Subdivision PH Comments

From: Holly Myers, Environmental Health Supervisor

Date: 03/17/2016

RE: SP-15-00010 Nelson Agriculture

JN AGRICULTURAL SHORT PLAT SP-15-XXXXX

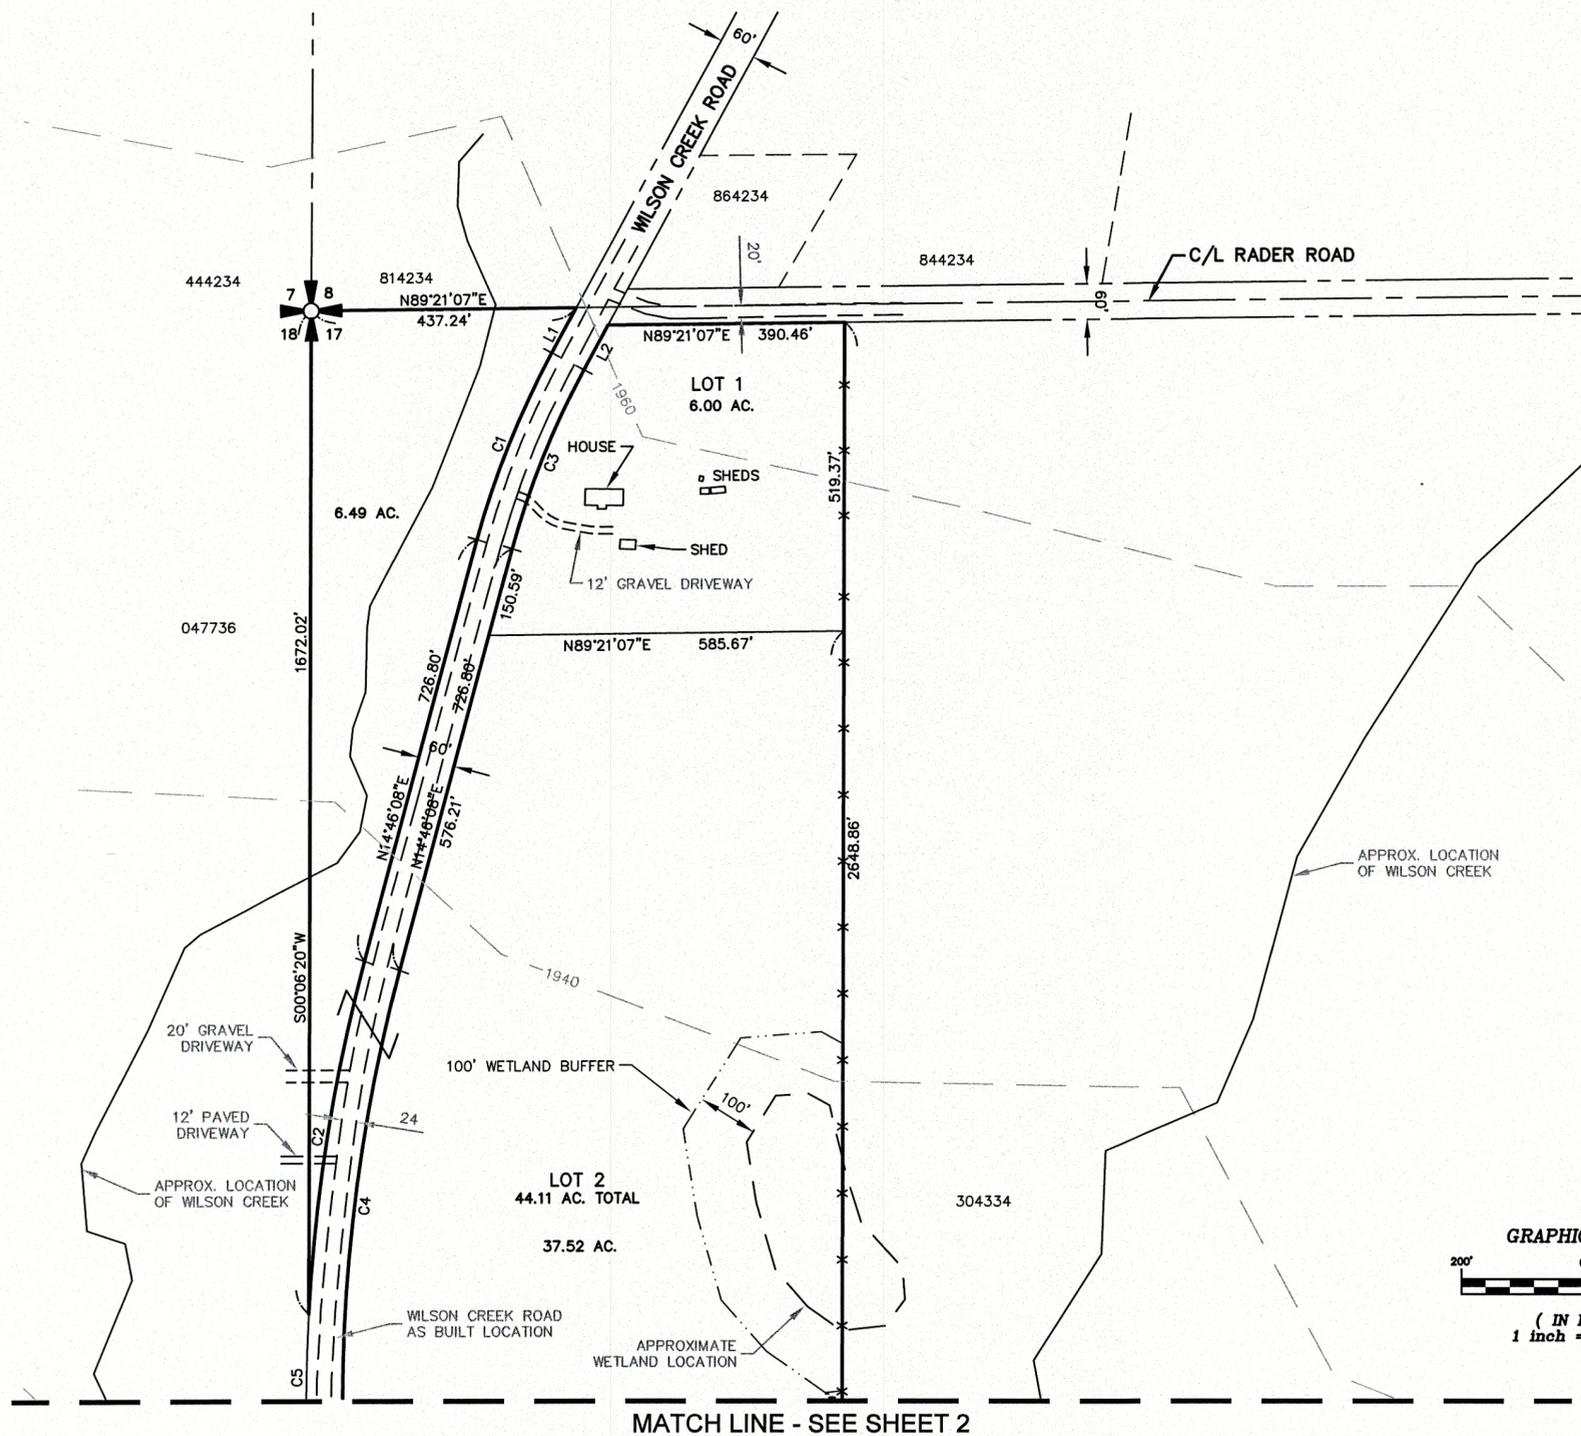
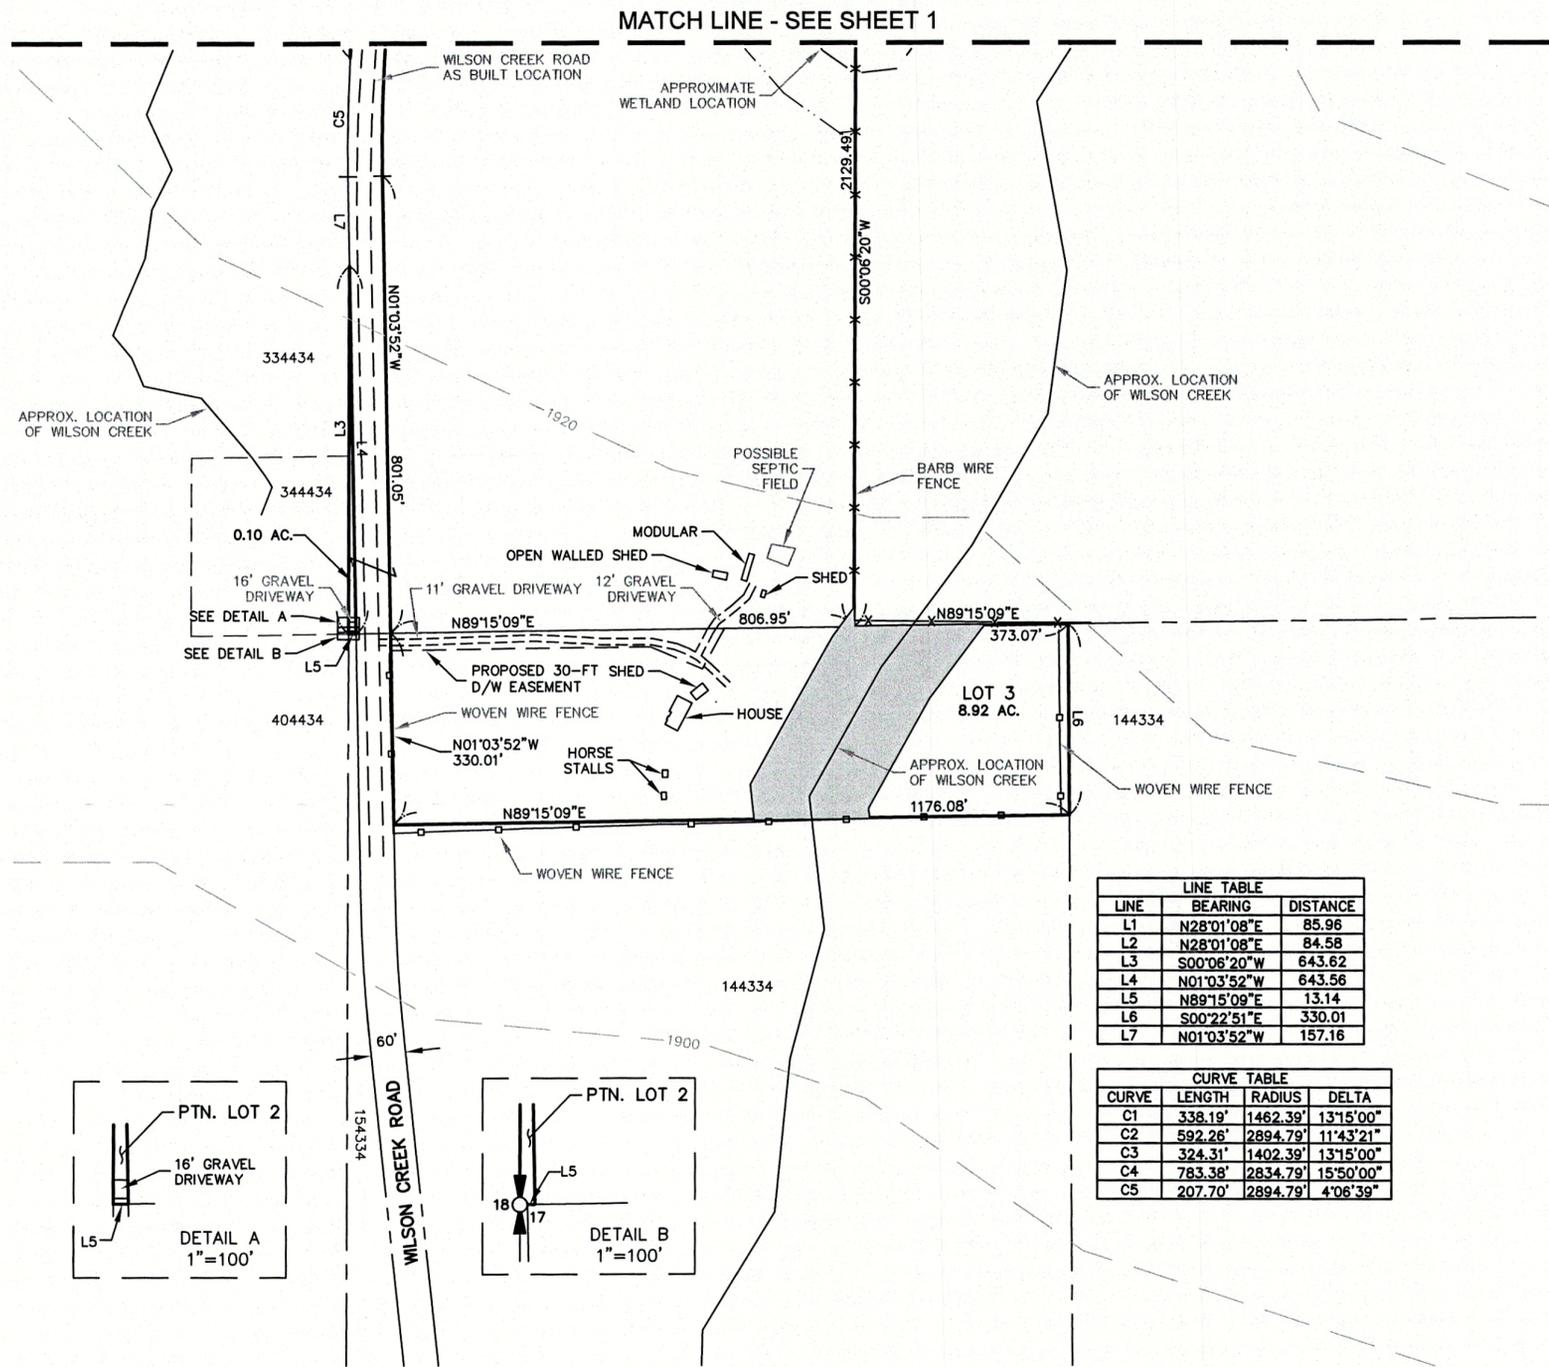
The current drawings do not include existing wells properly marked with clear setback measurements from structures, septic system components and boundary lines.

Unless every lot has existing septic and domestic water put to use at present, a soil log must be scheduled and completed for each lot and proof of water mitigation must be provided for lot.

All wells must meet the distance requirement of 50 feet from the property line, 50 feet from the septic tank and 100 feet from the drain field as per **Kittitas County Critical Areas Ordinance 17A.08.25, and KCC Chapter 13**. If existing wells do not meet the setback requirement from property lines, the two adjoining parcels nearest the well must enter into a legal, shared well-users agreement.
